**Re: OTT-22005690 -A0 Geotechnical Response to First Round of Comments from City of Ottawa
Proposed Addition to Residential Building, 68 Sweetland Avenue, Ottawa, Ontario
City of Ottawa Project No. D07-12-22-0106**

EXP Services Inc. (EXP) is pleased to present the geotechnical response to the City of Ottawa first round of comments regarding the EXP geotechnical investigation report dated June 20, 2022 for the above noted site address (EXP Project No. OTT-22005690-A0).

1 TREE CONSERVATION REPORT & LANDSCAPE PLAN
 SCALE: 1:150

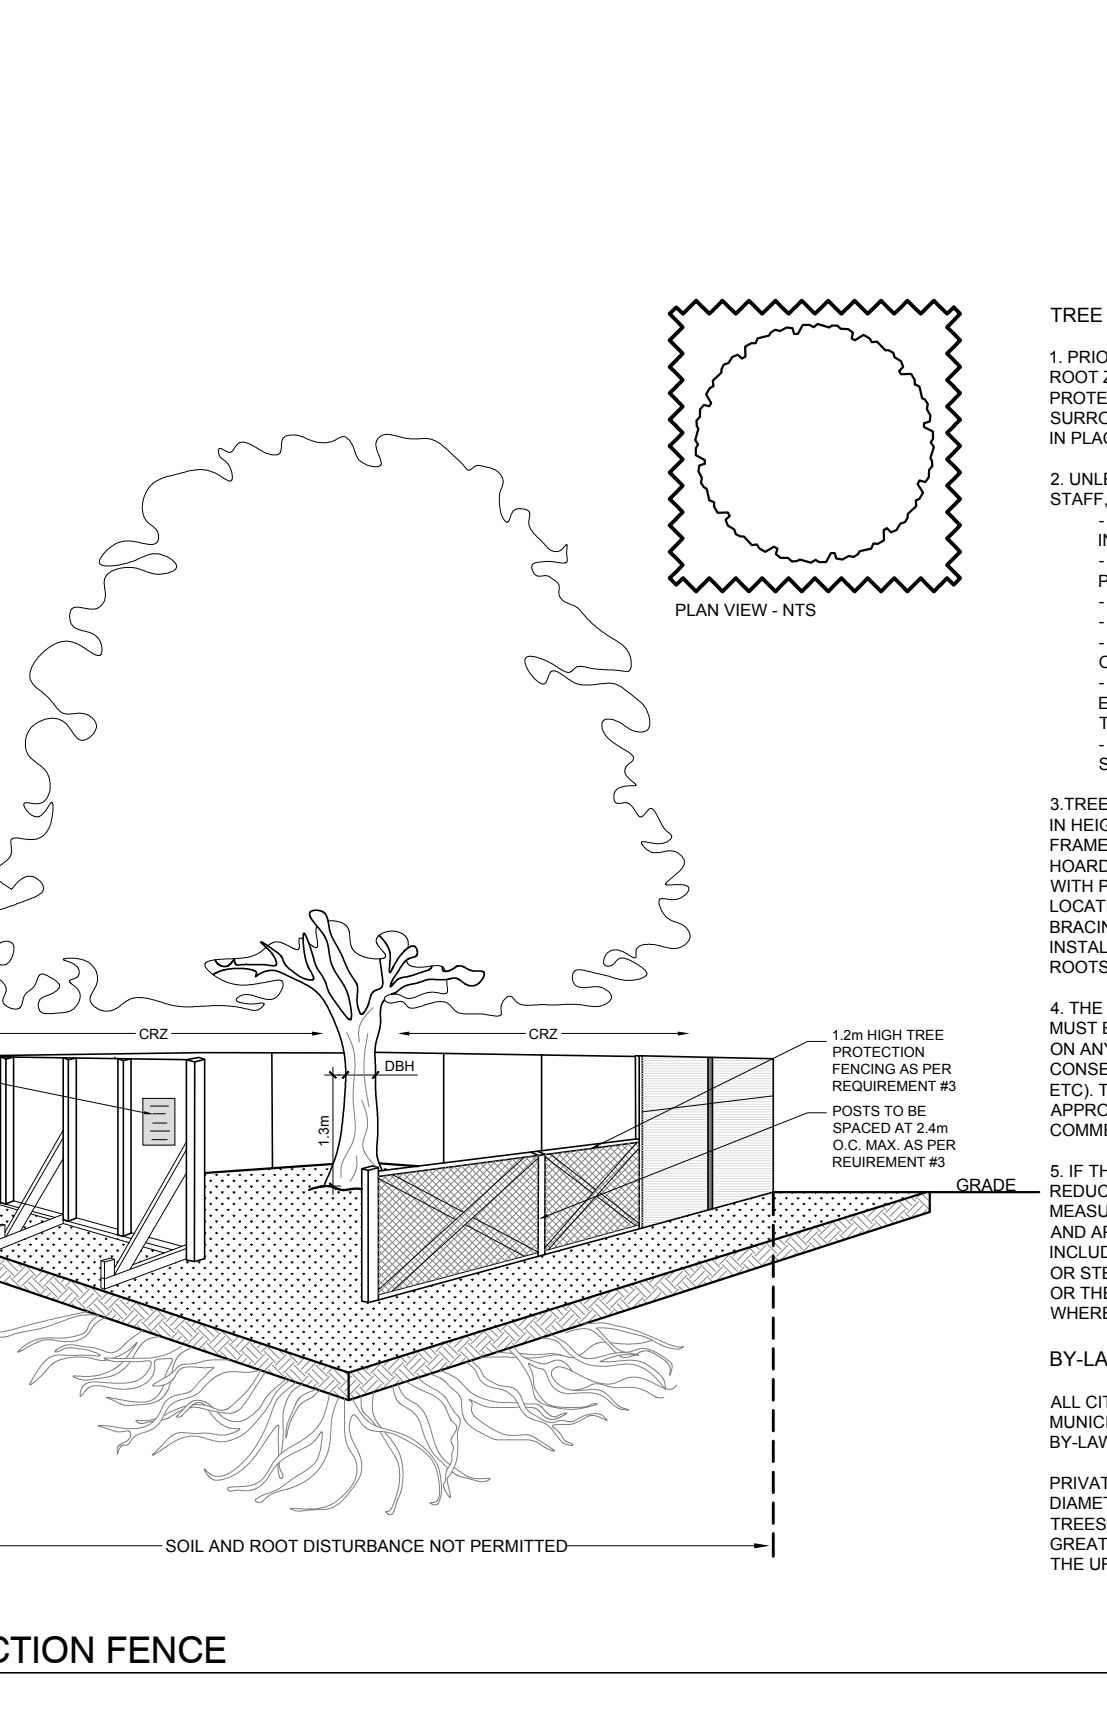
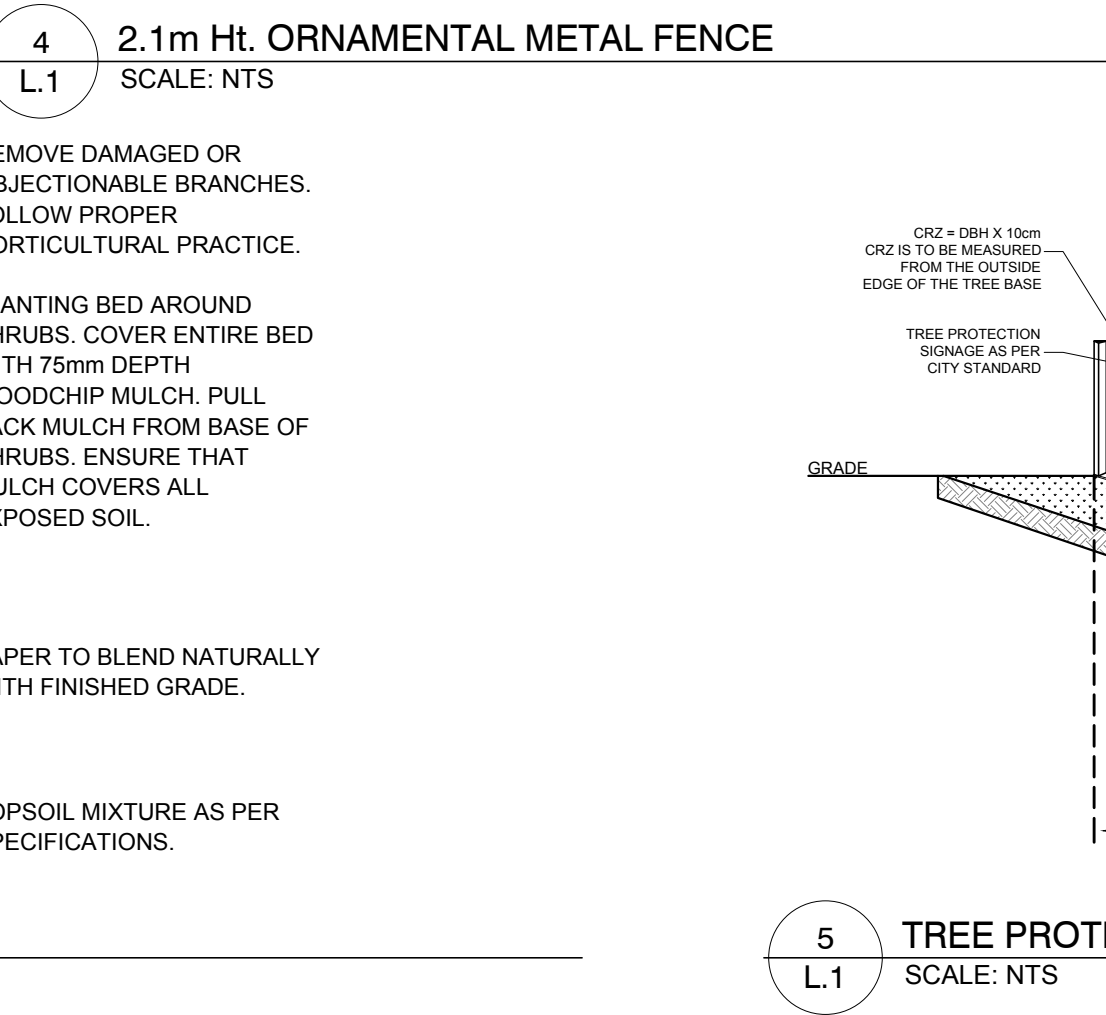
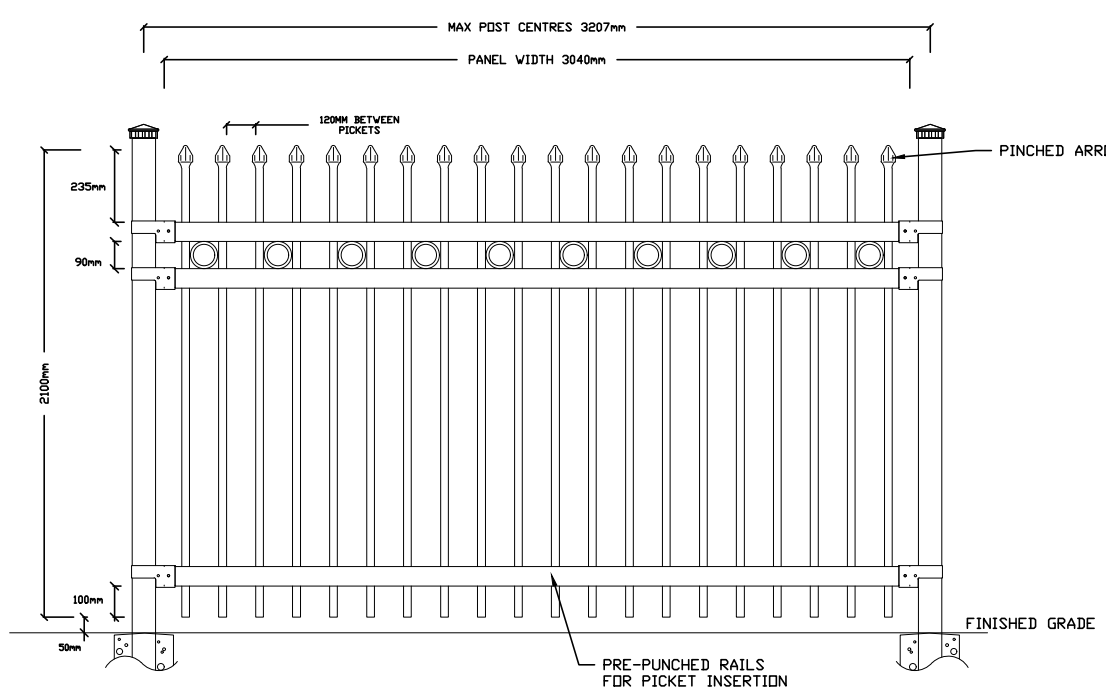
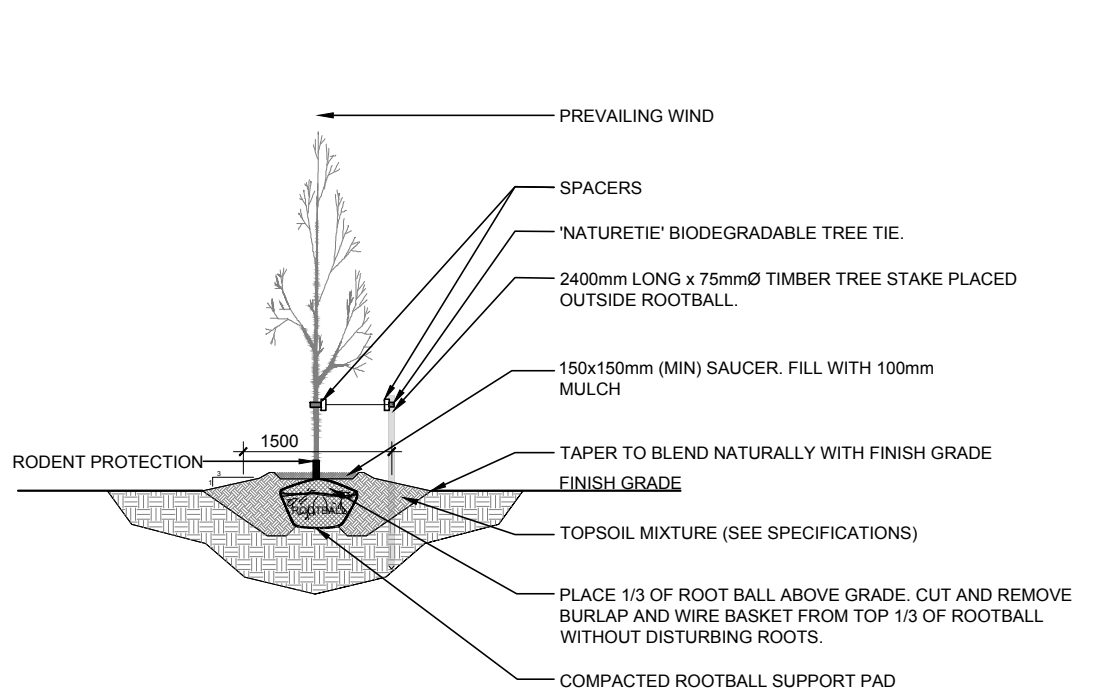
City of Ottawa Comment 24: Please provide landscape and grading recommendations as clay of high plasticity is present on site.

EXP Reply to Comment 24: *The site is underlain by marine clay. The test results of the native upper brown portion of the marine clay were compared with the document titled, "Tree Planting in Sensitive Marine Clay Soils – 2017 City of Ottawa Guidelines (2017 Guidelines)" and indicate the upper brown clay has a low/medium potential for soil volume change. For soils that have a low/medium potential for soil volume change, the 2017 Guidelines indicate that the tree to foundation setback distance and tree planting restrictions should be in accordance with the 2017 Guidelines. A landscape architect should be consulted to ensure the setbacks and tree planting restrictions are in accordance with the 2017 Guidelines.*
